August 9, 2013

**Subject: Proposed Truck Loading Area – 56 Milliken Street  
Application ID: 2013-181  
Comments from City of Portland Staff**

FST has received your memos and reviewed the comments (*italicized*) on the above referenced project. Your comments (*italicized*) and our responses (**bold**) are as follows:

DRAWN: CMW DATE: JULY 2013
DESIGNED: RJW SCALE: 1" = 20'
CHECKED: RJW JOB NO. 3215
FILE NAME: 3215-SP
SHEET C-2.0

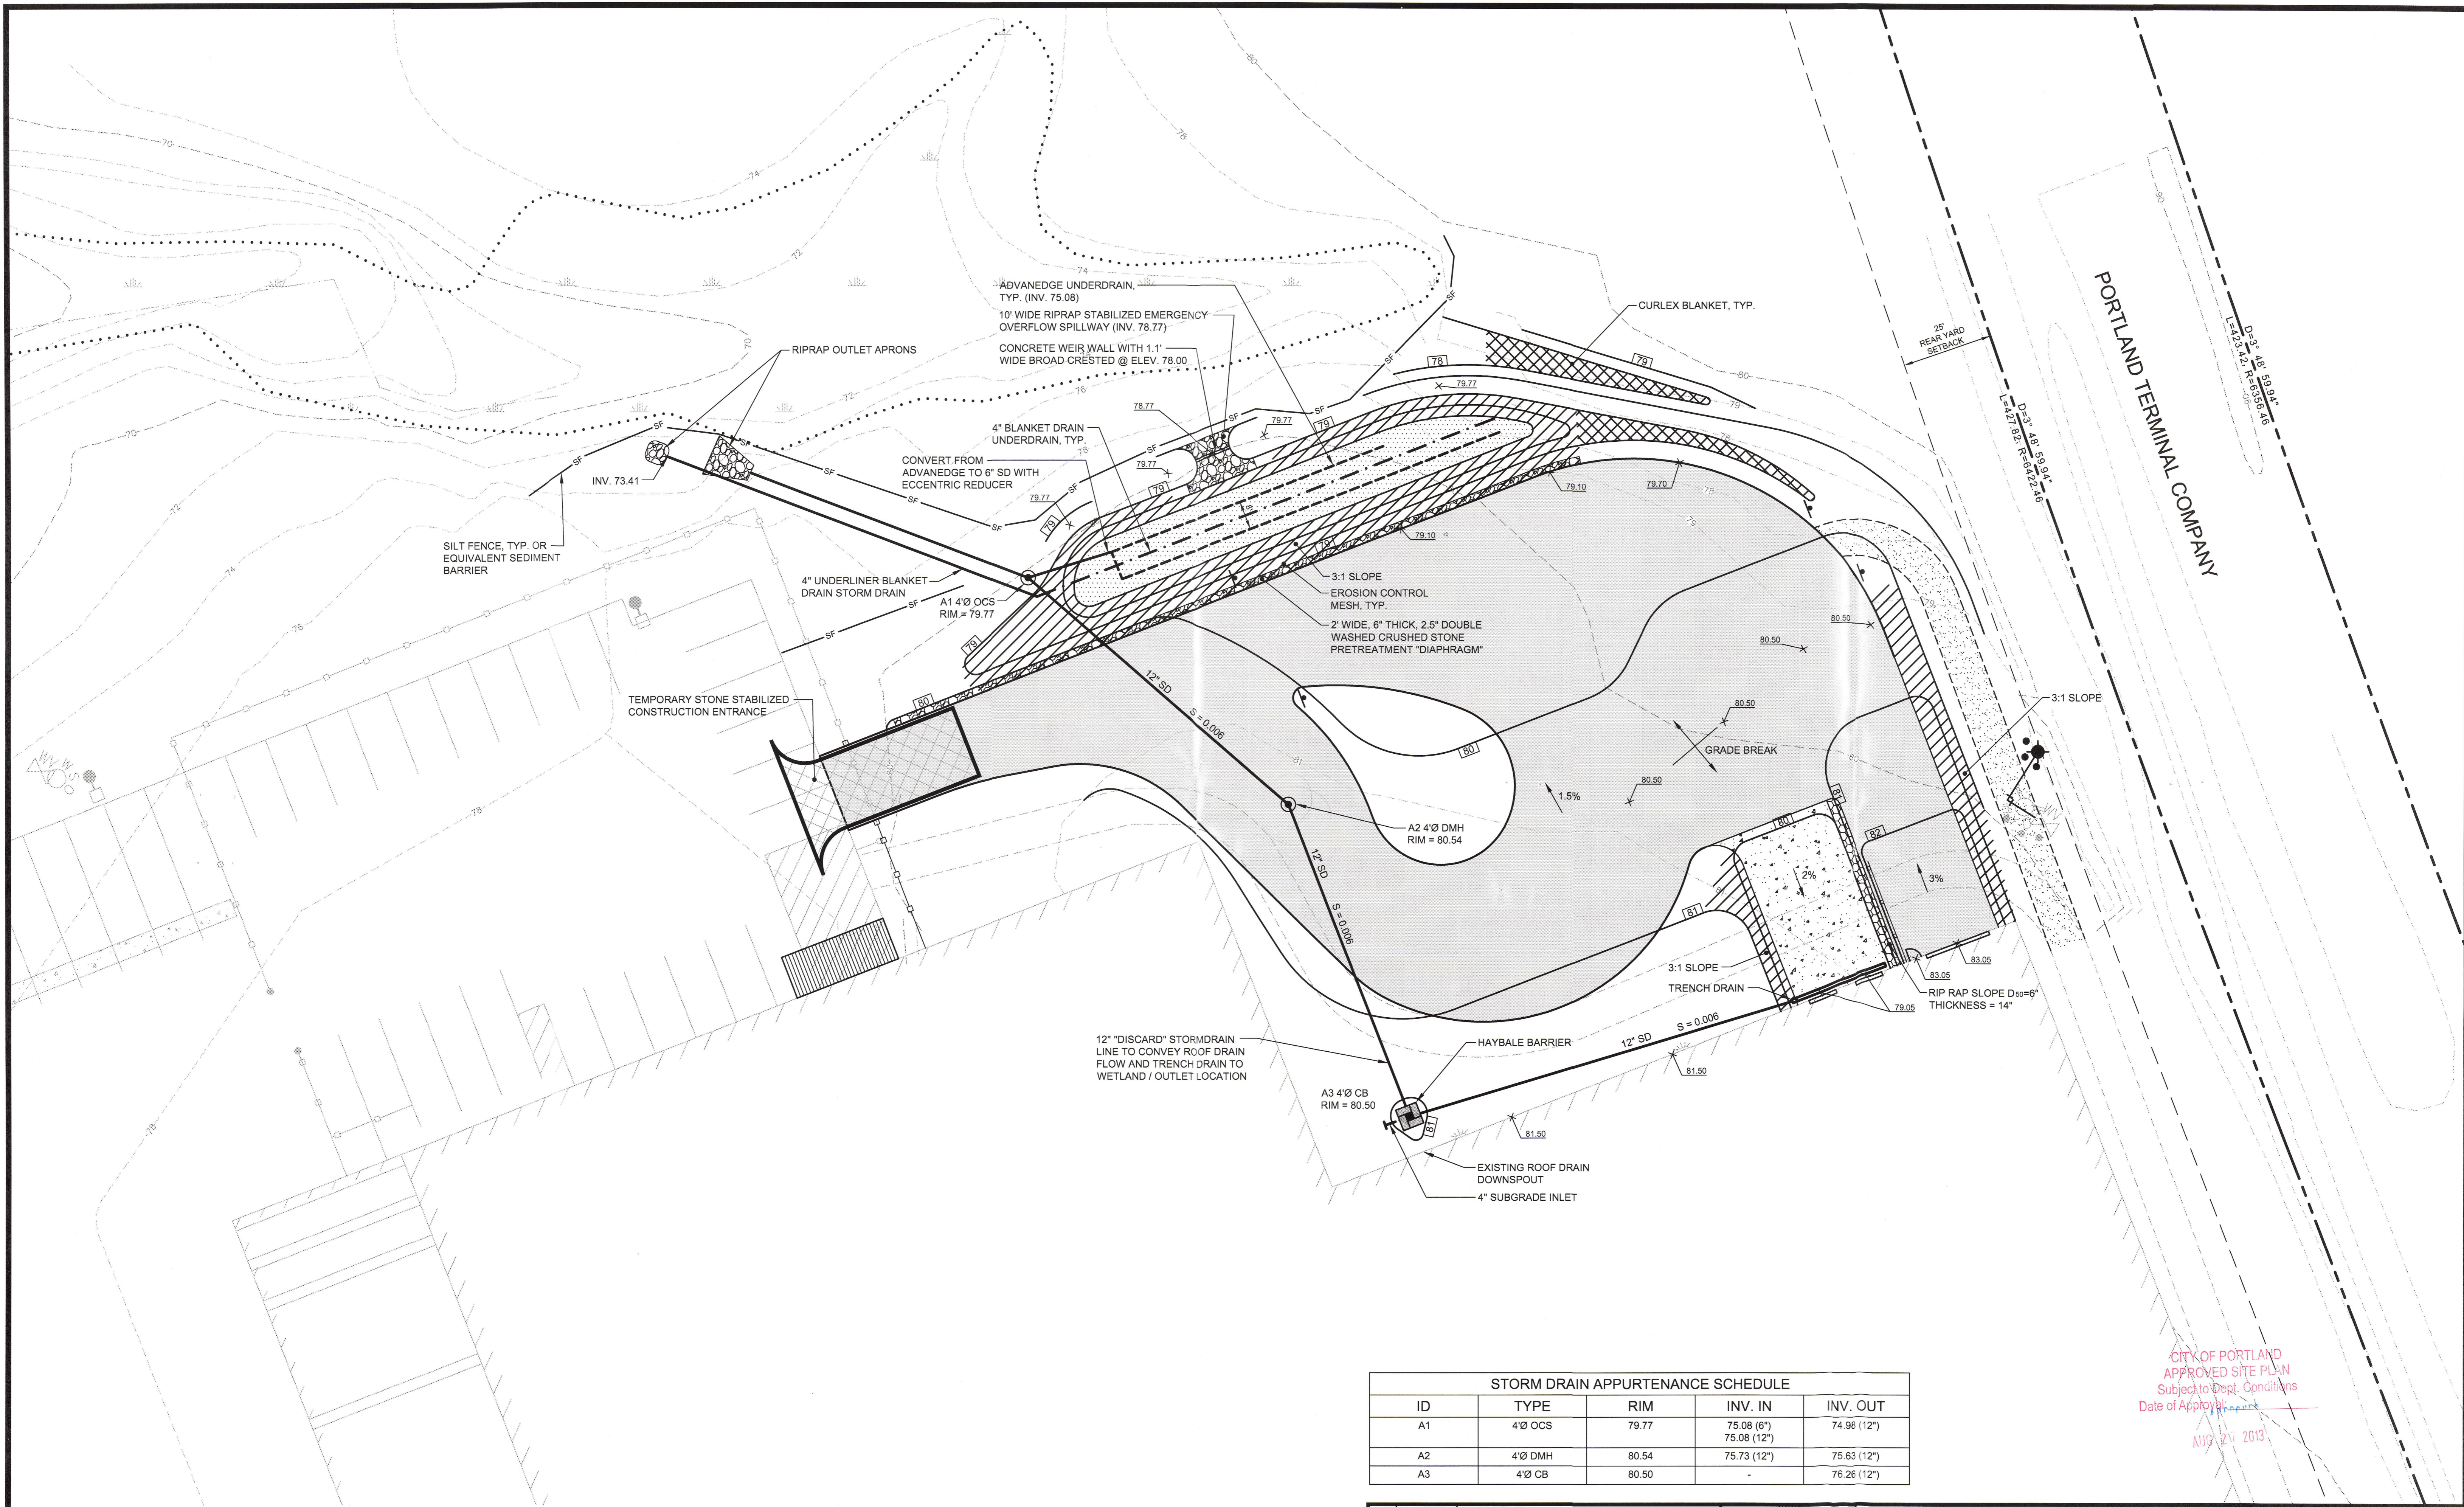
*The I-M zone has a minimum 10' pavement setback requirement. I measure approximately 53' to the RR tracks in the rear.*

**No response necessary. The maximum impervious ratio on Sheet C-2.0 has been revised from 100 percent to 75%.**

DRAWN: CMW DATE: JULY 2013
 DESIGNED: RJW SCALE: 1" = 20'
 CHECKED: RJW JOB NO. 3215
 FILE NAME: 3215-SP
 SHEET **C-3.0**

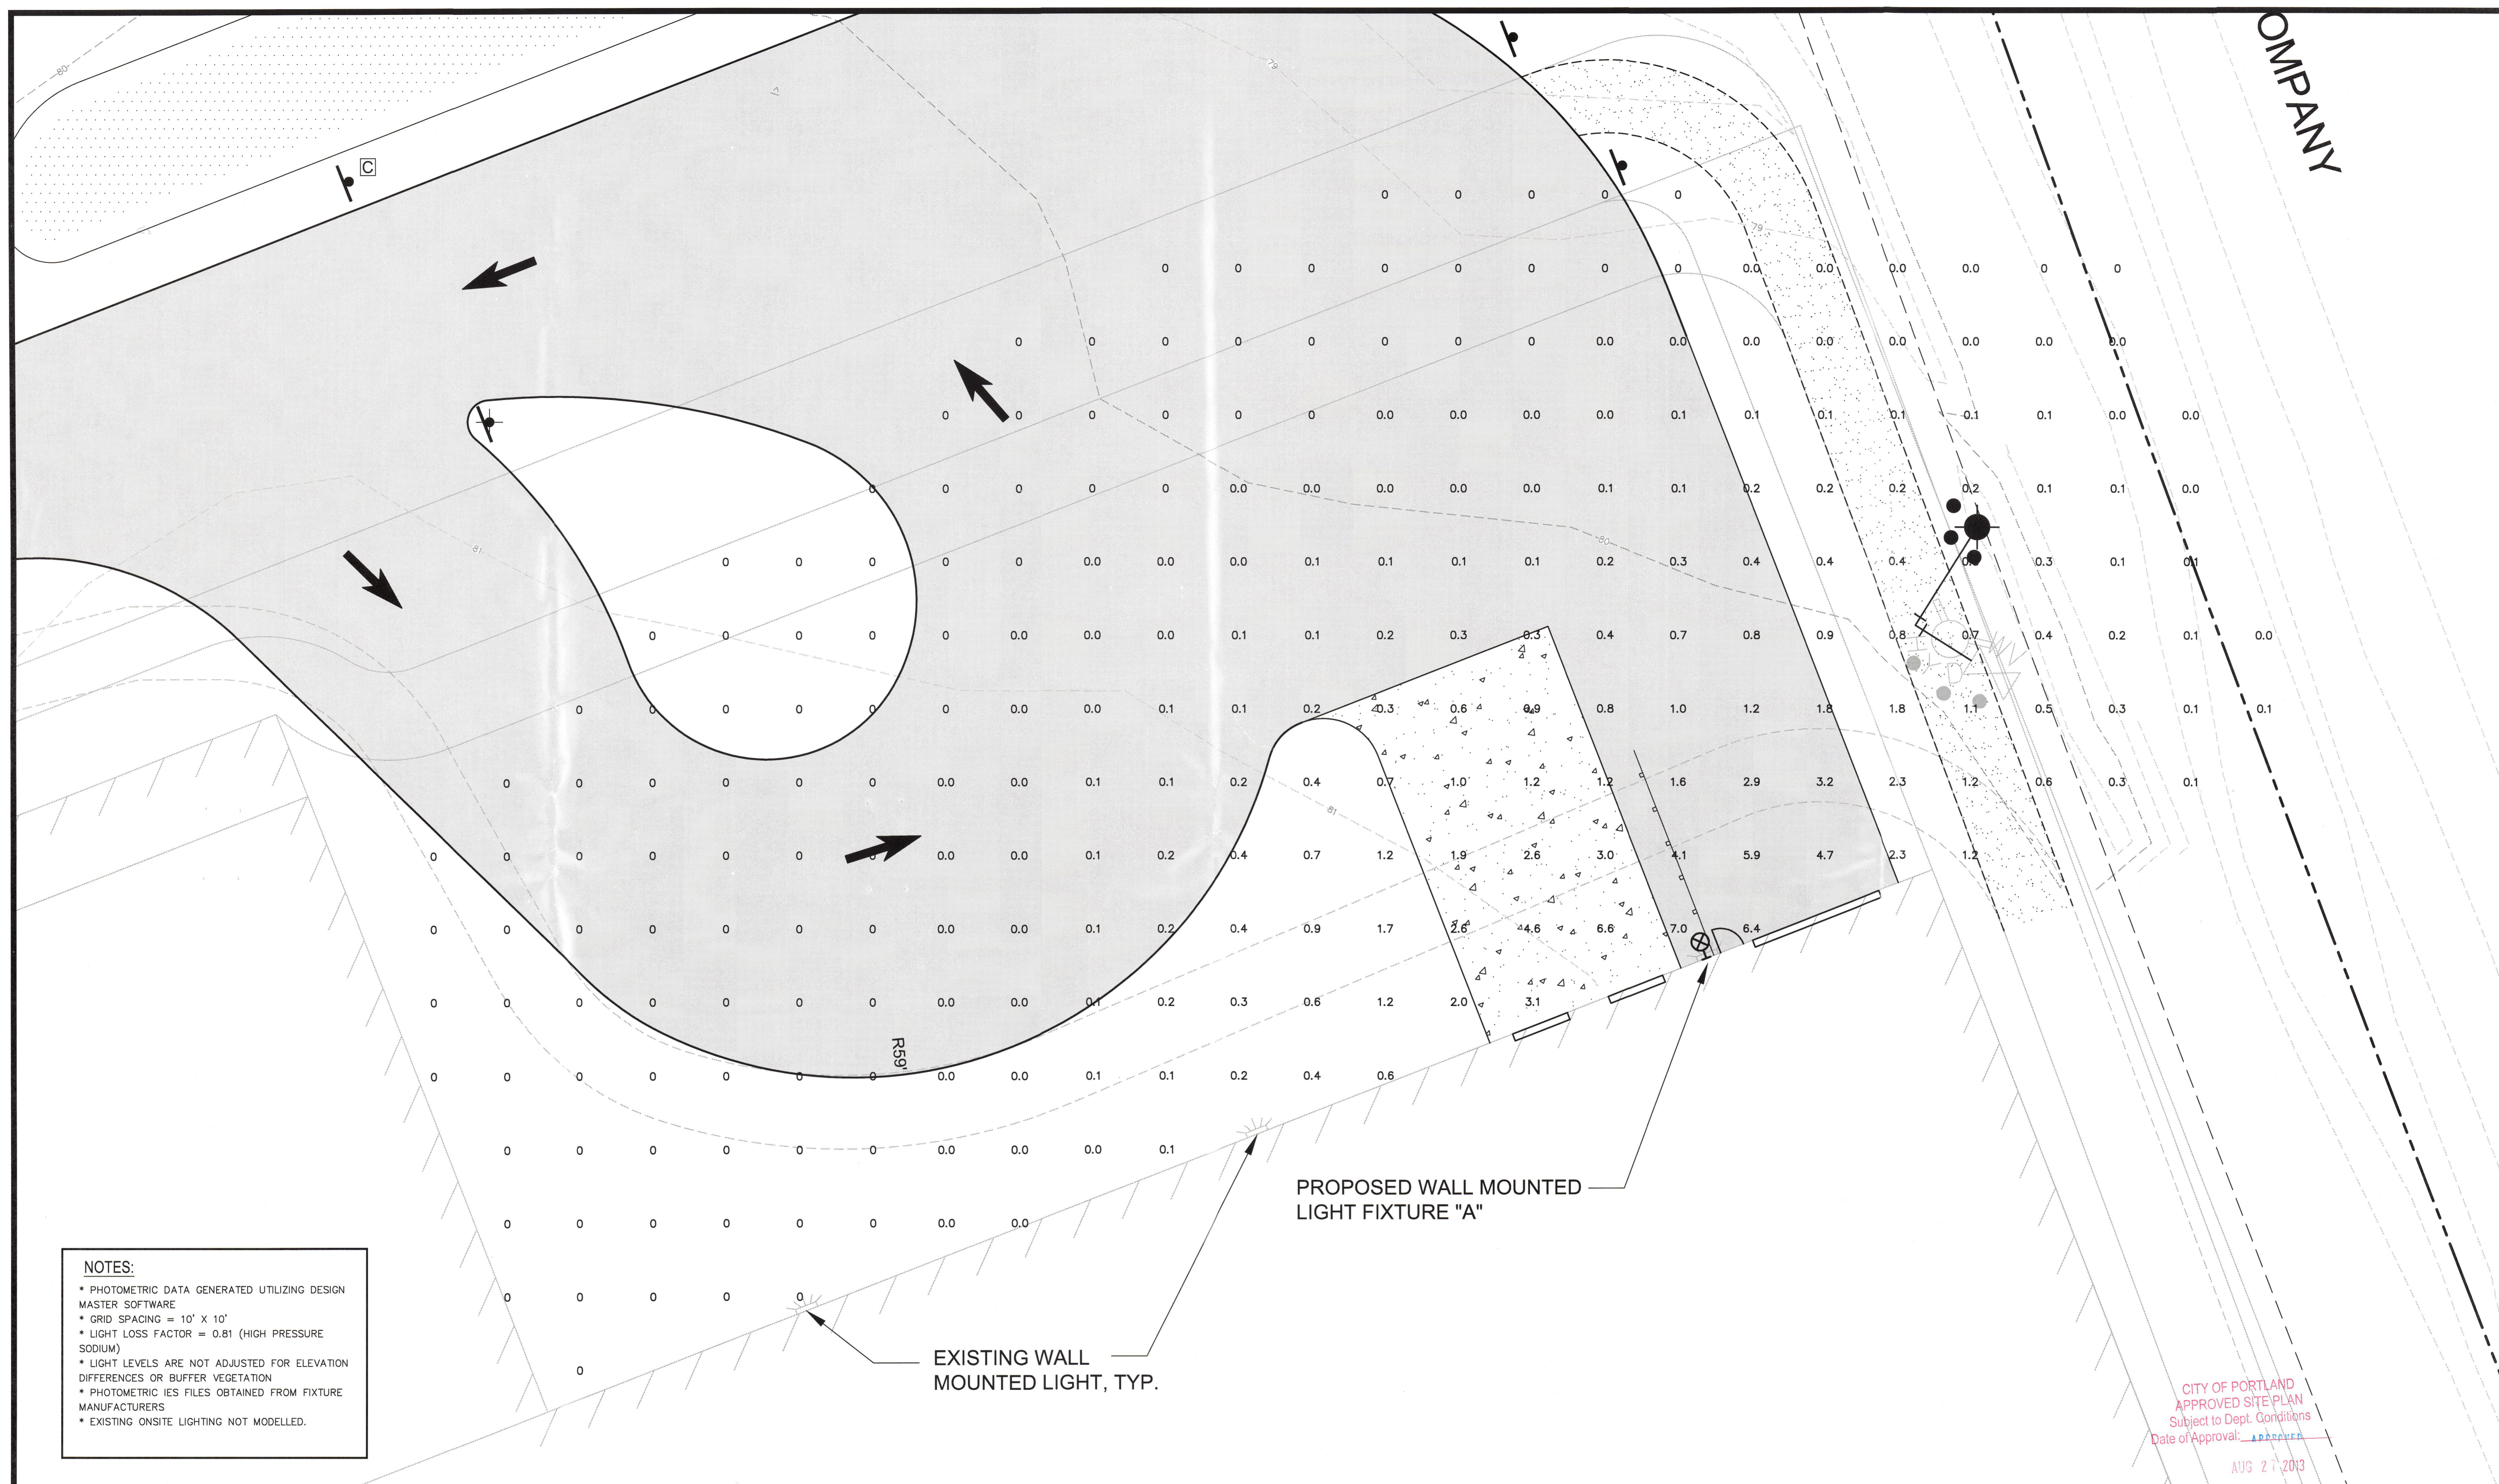
*2a) Pretreatment devices such as grassed swales, grass or meadow filter strips, and sediment traps shall be provided to minimize the discharge of sediment to the underdrained soil filter. Pretreatment structures shall be sized to hold an annual sediment loading calculated using a sand application rate of 50 cubic feet per acre per year for sanding of roadways, parking areas, and access drives within the subcatchment area. The current design does not reflect these features for the management of runoff from much of the paved area.*

**A 175' long, two foot wide by 6 inch deep 2.5" crushed stone diaphragm has been added along the edge of the proposed pavement for pretreatment based on 40 percent void space. This provides approximately 140 c.f. of volume which more than satisfies the requirements. The long term maintenance of this pretreatment measure will involve inspection and monitoring of the stone area for sediment build up and debris. Revised Sheet C-3.0 shows the stone diaphragm. A detail has been added to Sheet C-6.1.**
